Application Ref:	3/2021/0256	 Ribble Valley Borough Council www.ribblevalley.gov.uk
Date Inspected:	10/06/2020	
Officer:	RB	
DELEGATED ITEM FILE REPORT:		APPROVAL

Development Description:	Proposed single storey detached garage, front extension to adjacent porch, removal of three windows from kitchen and one from utility as a revision to the original planning consent ref 3/2020/0304
Site Address/Location:	7 Tennyson Avenue, Read, BB12 7RN

PROPOSED DETACHED GARAGE

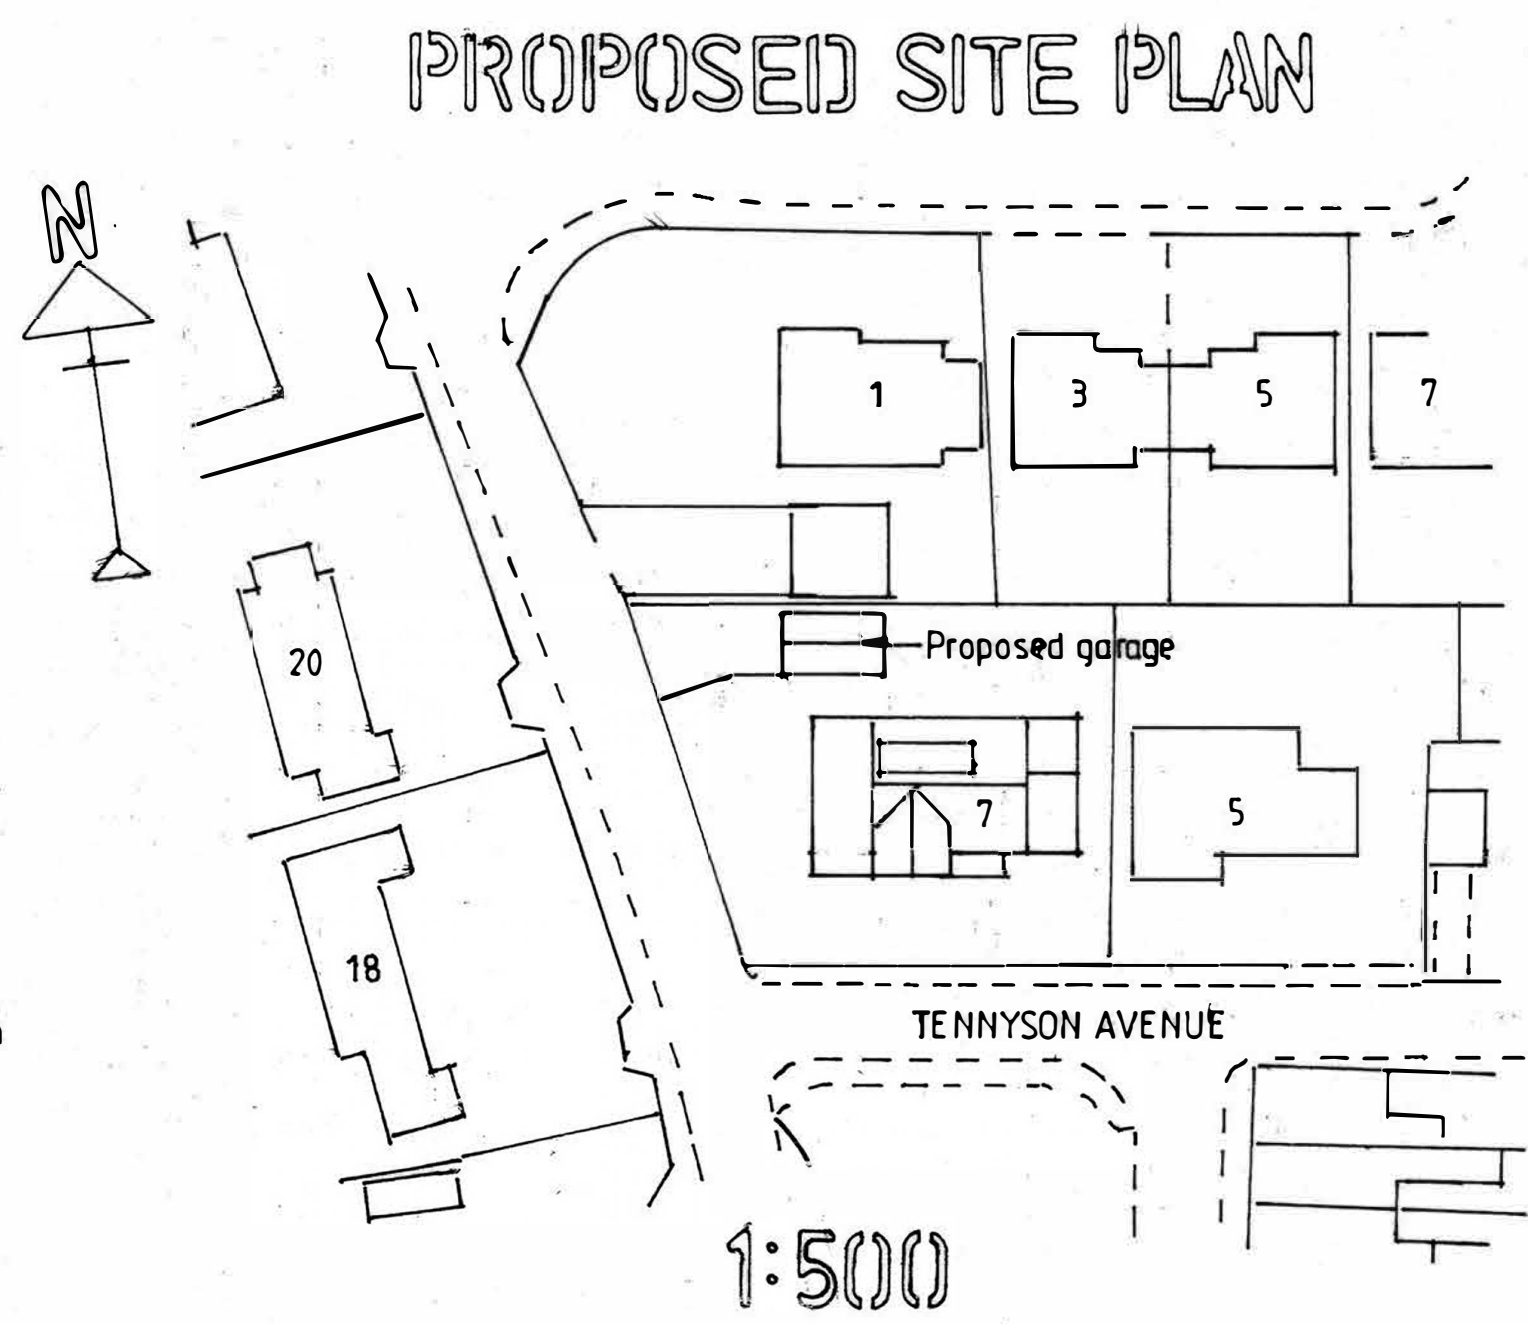
ASSESSMENT OF PROPOSED DEVELOPMENT:
Site Description and Surrounding Area: The application relates to a detached dwelling located within Read. The area is popularised by detached bungalow properties as well as two storey dwellings. The proposed benefits from parking to front with an attached garage and a private garden area to the side and rear.
Proposed Development for which consent is sought: Consent is sought for the erection of a detached garage to the north west corner of the garden area for the property on the footprint of an existing off street parking area. The garage will measure 3.5m

by 6.5m and will have a pitch roof measure 2.2m at the eaves and 3.75m at the ridge. It is proposed to resurface approximately 10m by 5m of ground to provide access to the garage off George Lane. The garage will be faced with render on a Staffordshire blue brick plinth and the roof will be concrete tiles with a aluminium door.

The proposed garage will be sited to the north west corner of the application dwellings garden area and will be sited adjacent to the garage that is within the curtilage of no 1 St. Johns Close. The proposed garage will exceed the height of the neighbour's flat roof garage and concerns have been raised that the height of the garage would result in the loss of light to the rear windows of no 1 St. Johns Close. There is a separation distance of 10m from this rear elevation and therefore it is considered that there would not be a significant loss of light to this neighbour, nor would there be detrimental overbearing impact that would warrant refusal of the application.

The proposed garage will be set back from the highway by 10m, will be single storey and will be constructed in materials that will be in keeping with the recently developed property. Therefore, it is considered that the development will not be viewed as a prominent addition on the street scene. Concerns have been raised regarding the garage having a pitch roof as most of the garages in the area have flat roofs, including the attached garage that the application dwelling already benefits from. The applicant's agent has confirmed the reason for the pitch roof is so that it matches the pitch of the house. Although the pitch roof will not have a similar appearance to the flat roof garage it will be adjacent to it is not considered that this design would have a detrimental impact on the visual amenity of the area.

LCC highways originally had concerns with the proposed surfacing as without an exploratory ground investigation, the substratum may not be free draining and thus not support the concept of permeable hardstanding. The applicant's agent subsequently amended the plans to show an aco drain on the driveway. Highways are satisfied within this drainage scheme and therefore have no

PROPOSED GROUND FLOOR PLAN

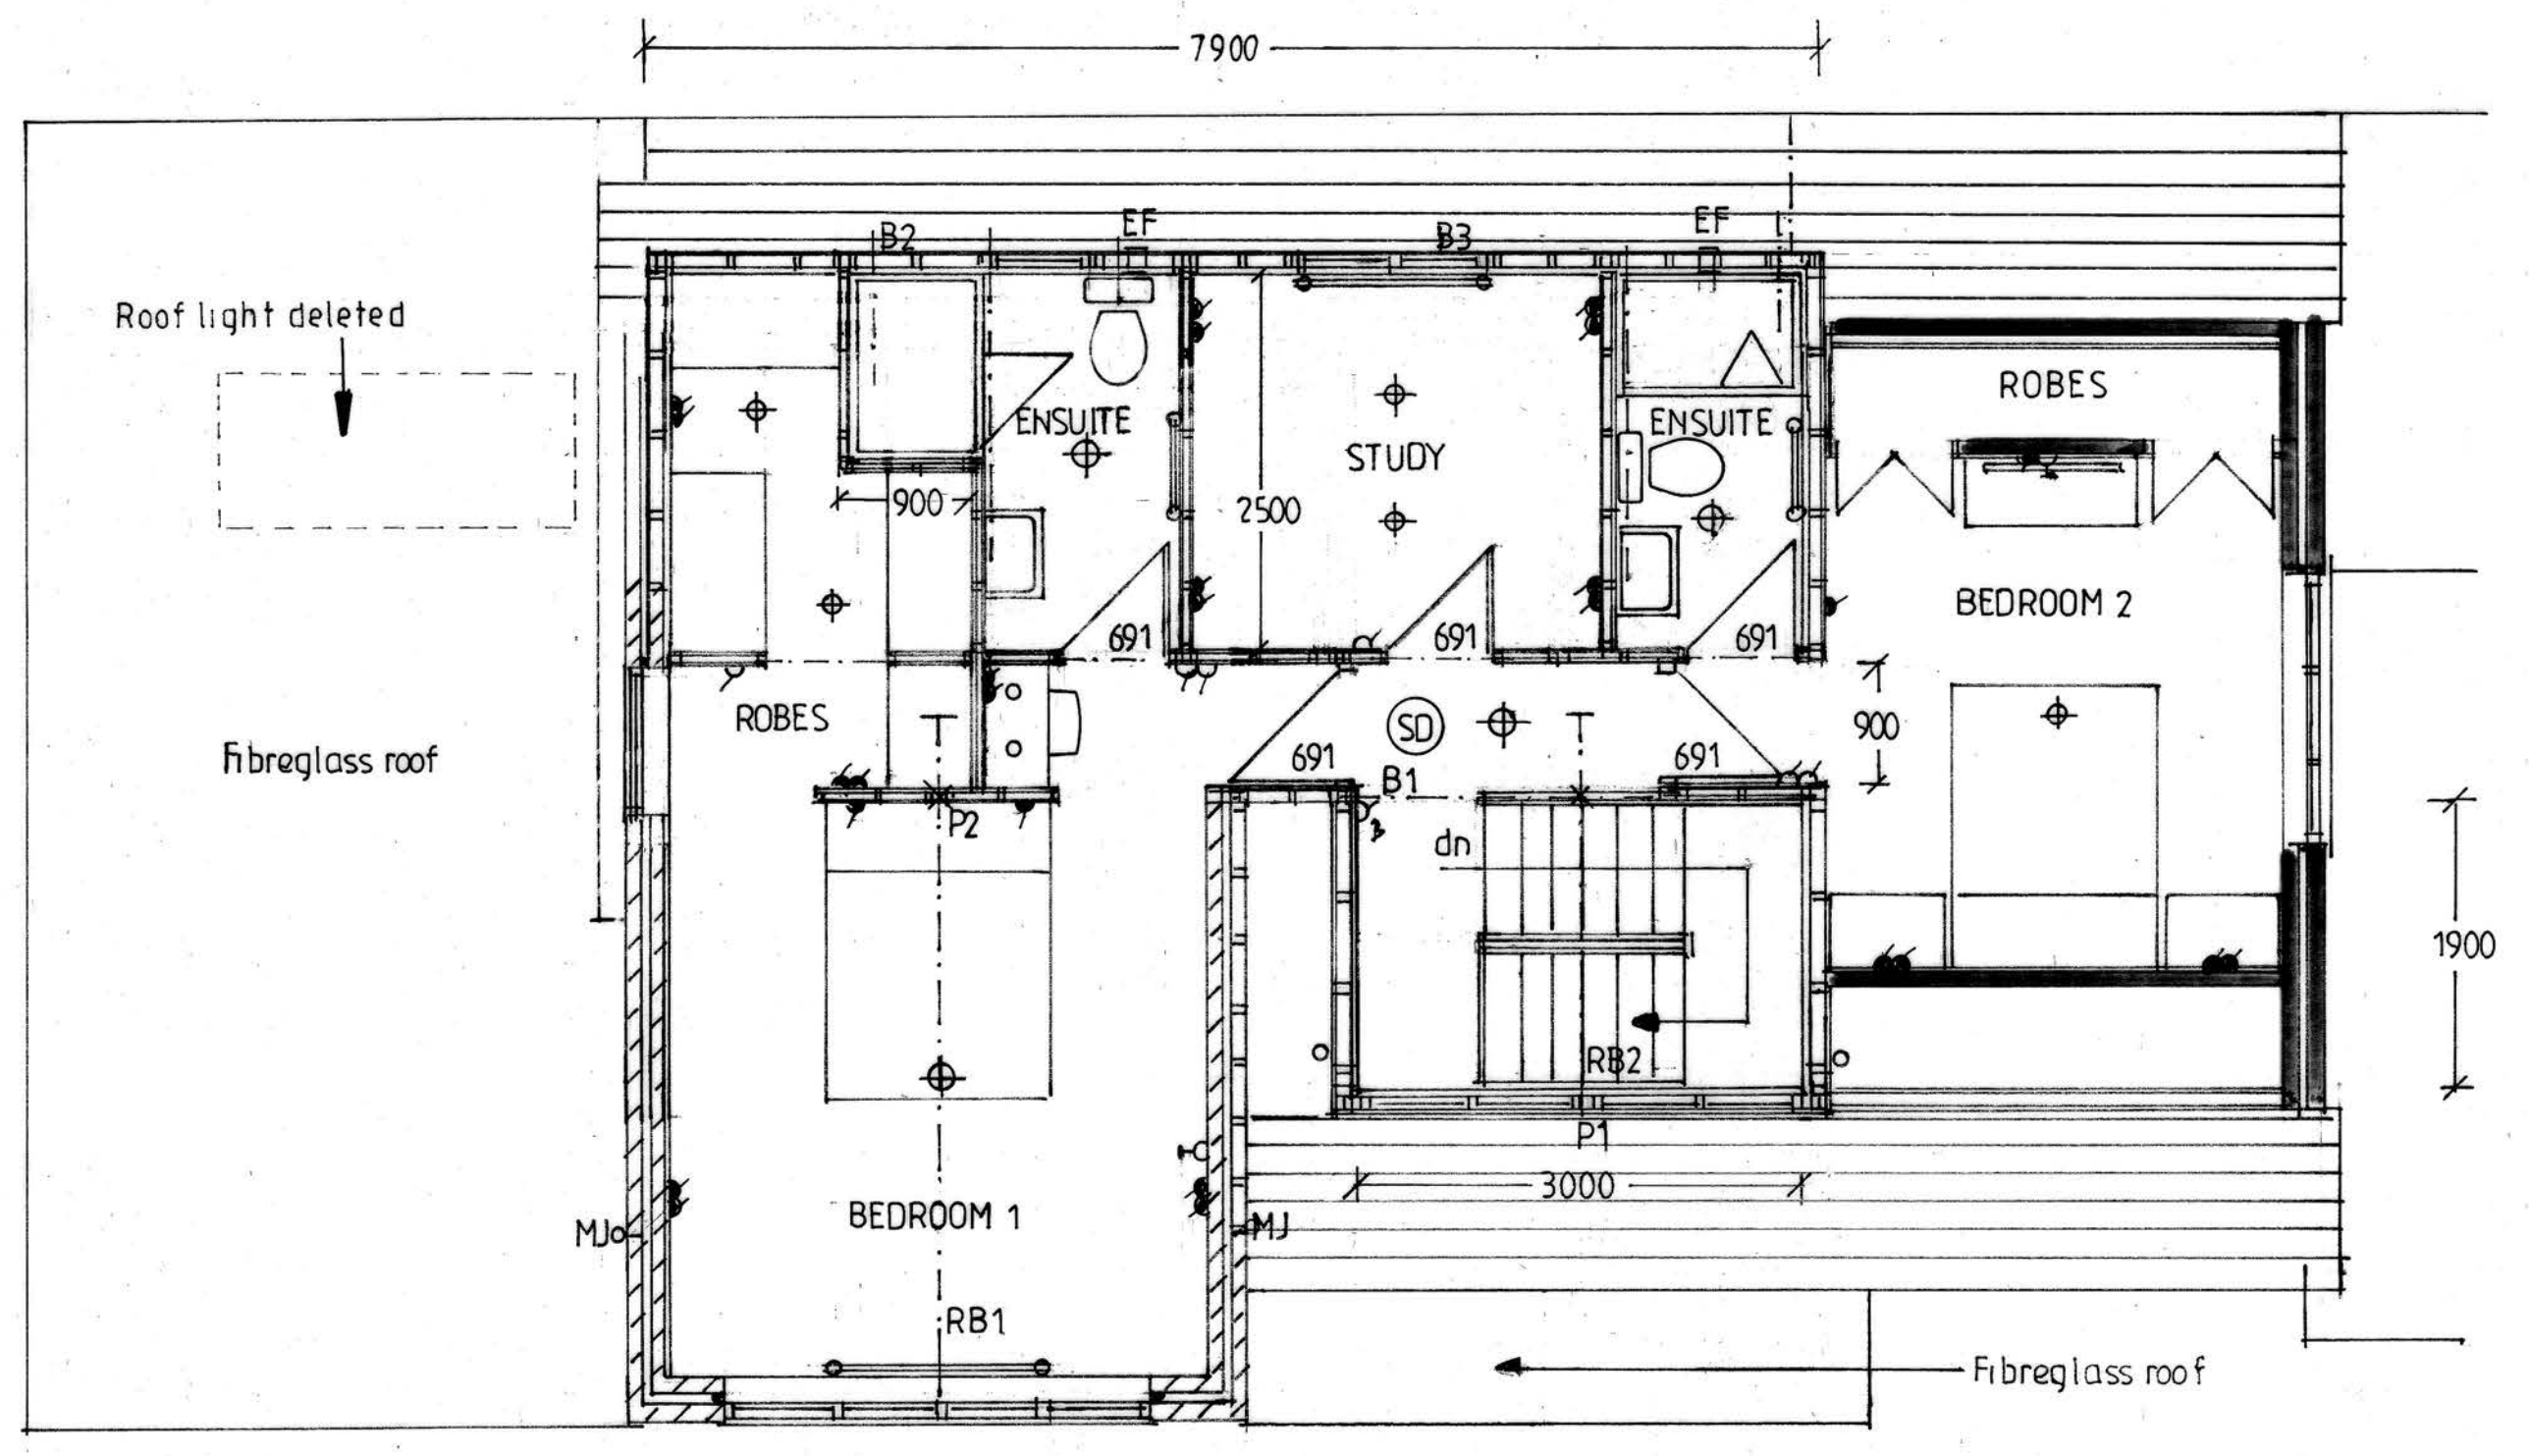
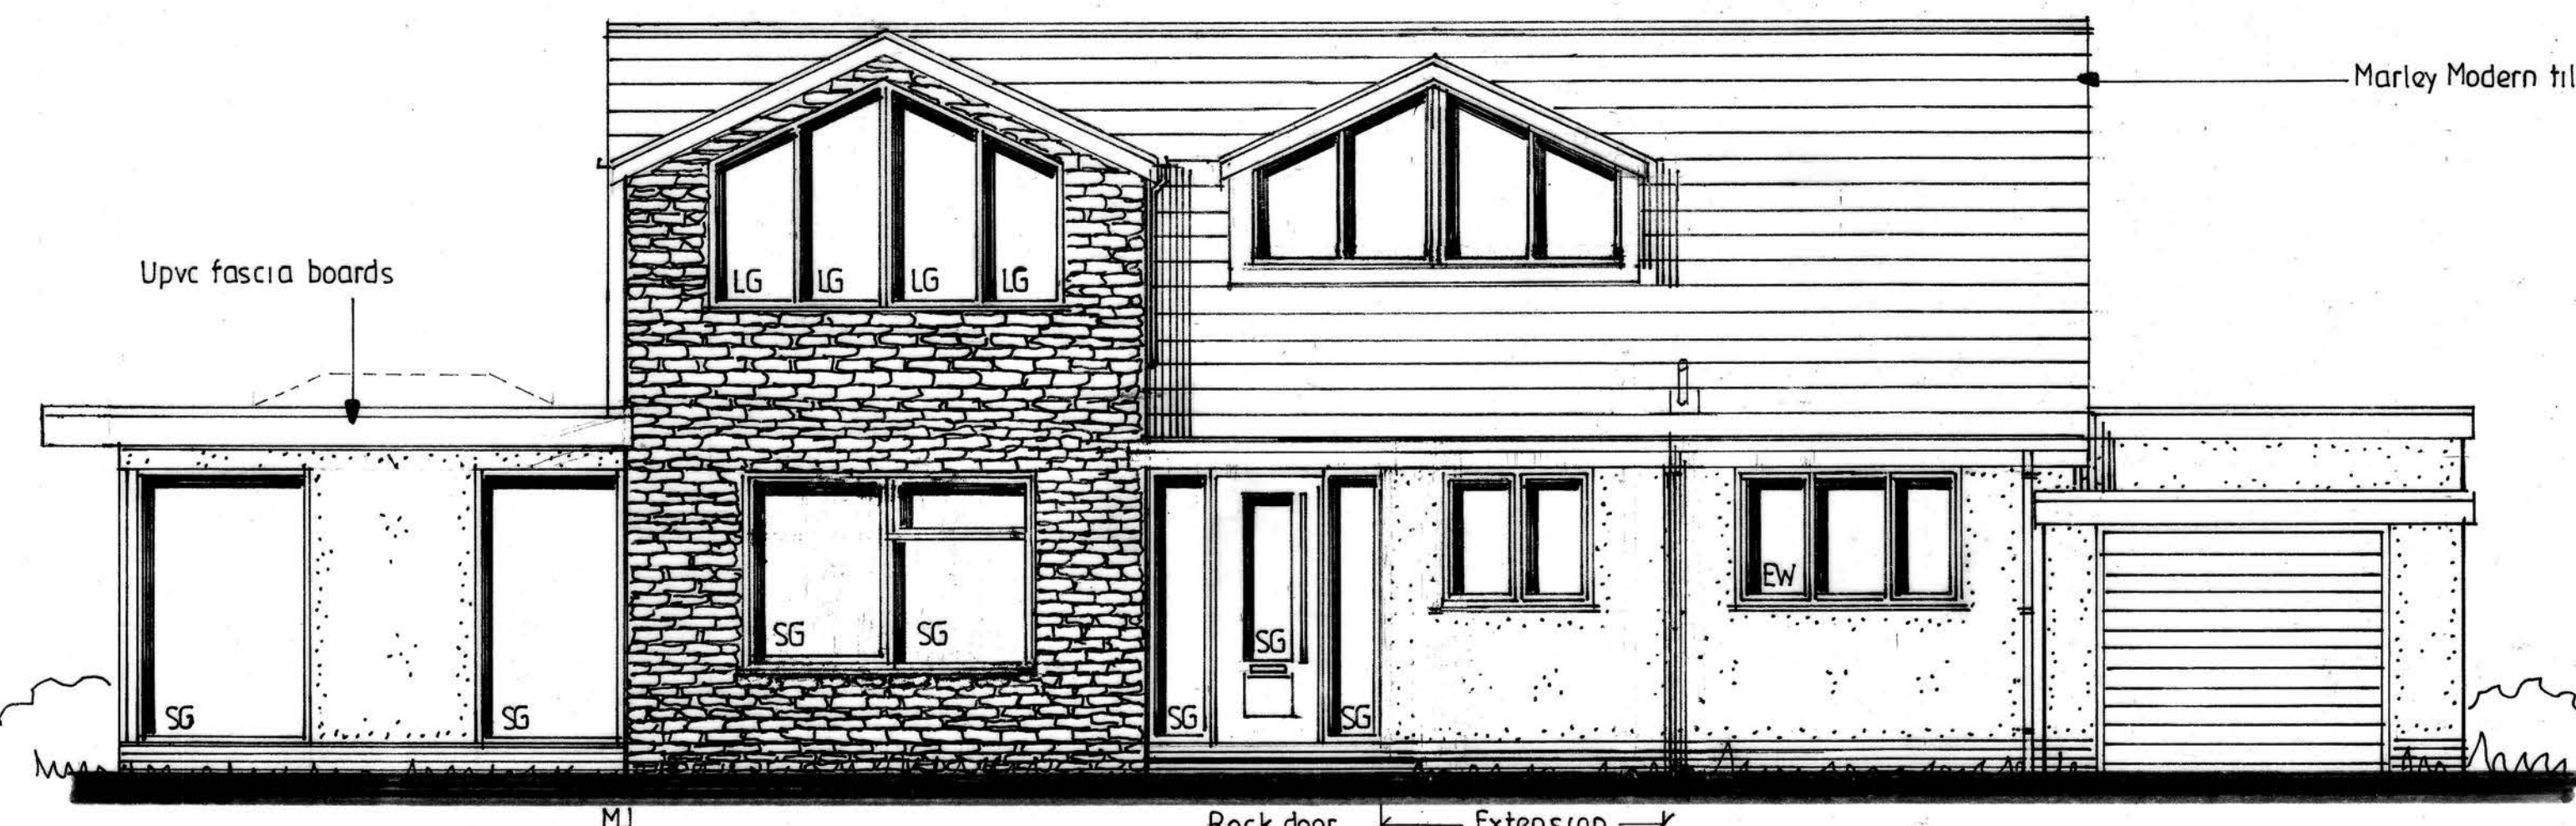
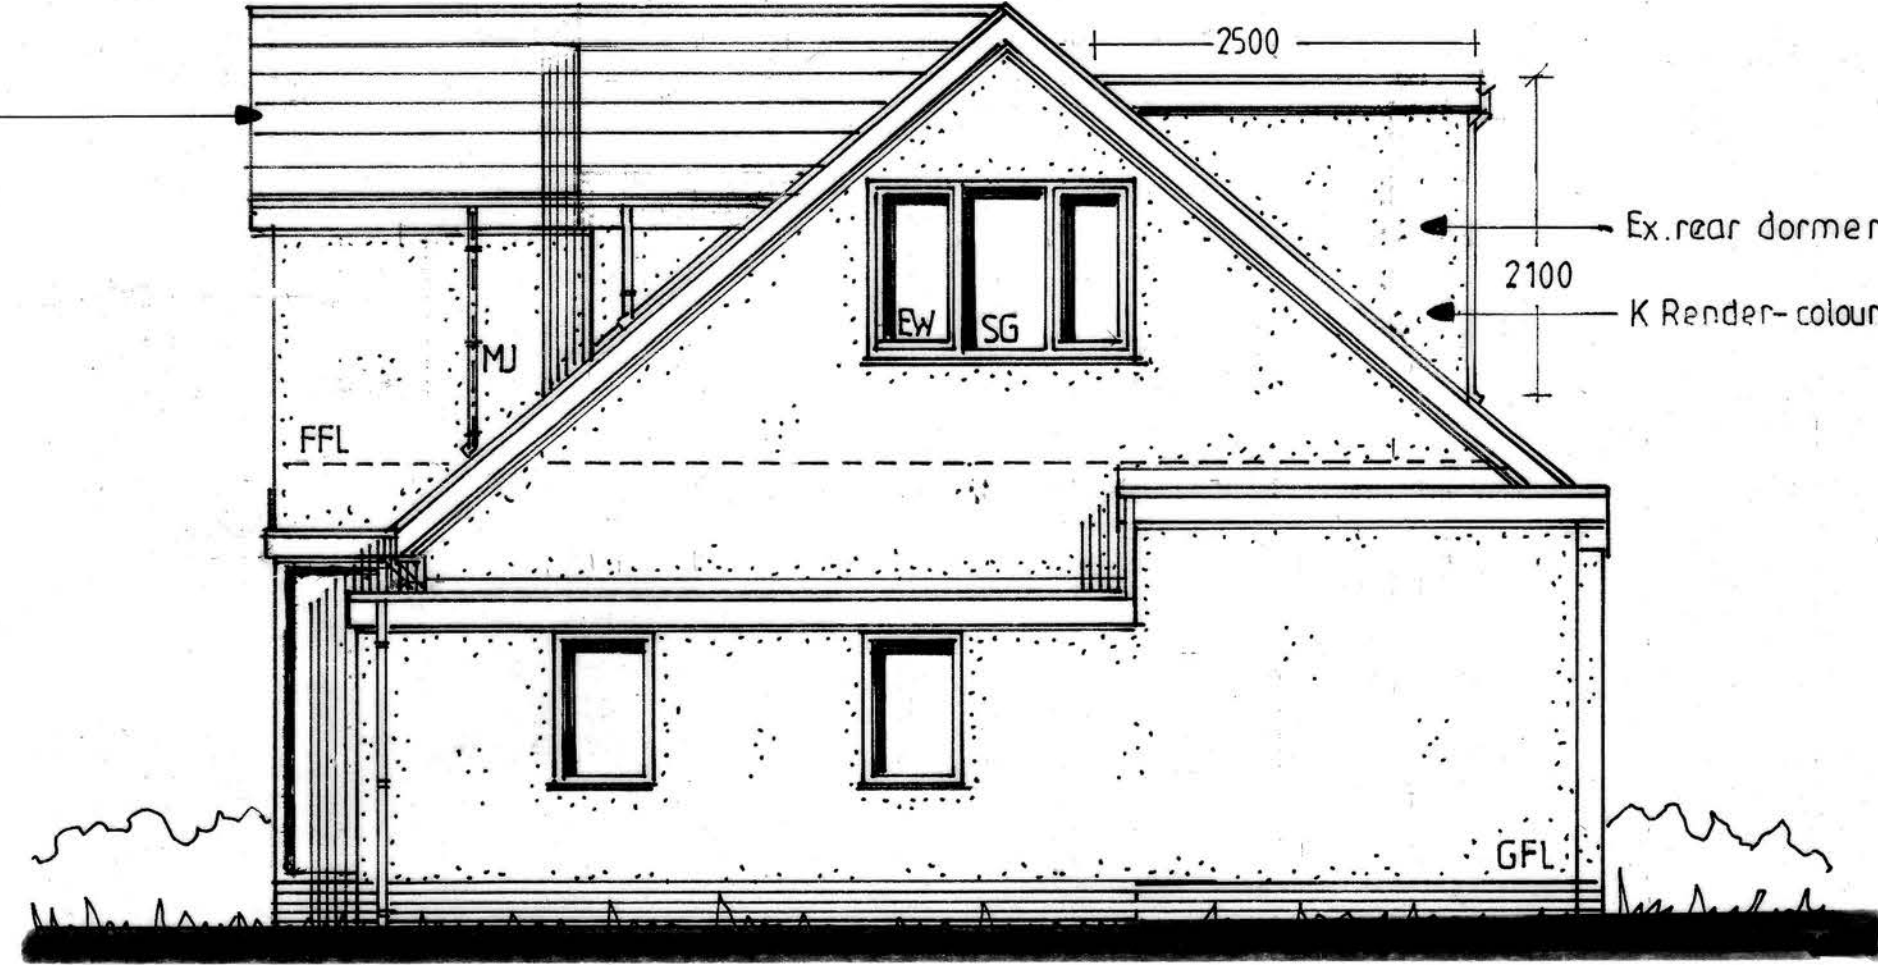
It is also proposed to extension the porch to the front of the dwelling. The extension will take the width of the porch to 2.3m in width and will create an entrance hall into the property. The extension will project forwards of the front elevation by approximately 1m. The extension will have a flat roof measuring 2.5m in total height.

The proposed works to the front of the property will not negatively impact any neighbouring dwelling as the extension is minimal and there is a sufficient separation distance between the site and the closest neighbour.

The application site occupies a corner plot and is therefore visible from Tennyson Avenue and George Lane. The proposed extension to the front porch would have negligible impact on the visual amenity of the area as the footprint of the extension is minimal and the max height measures at the eaves height of the bungalow therefore the extension would remain subservient to the main dwelling.
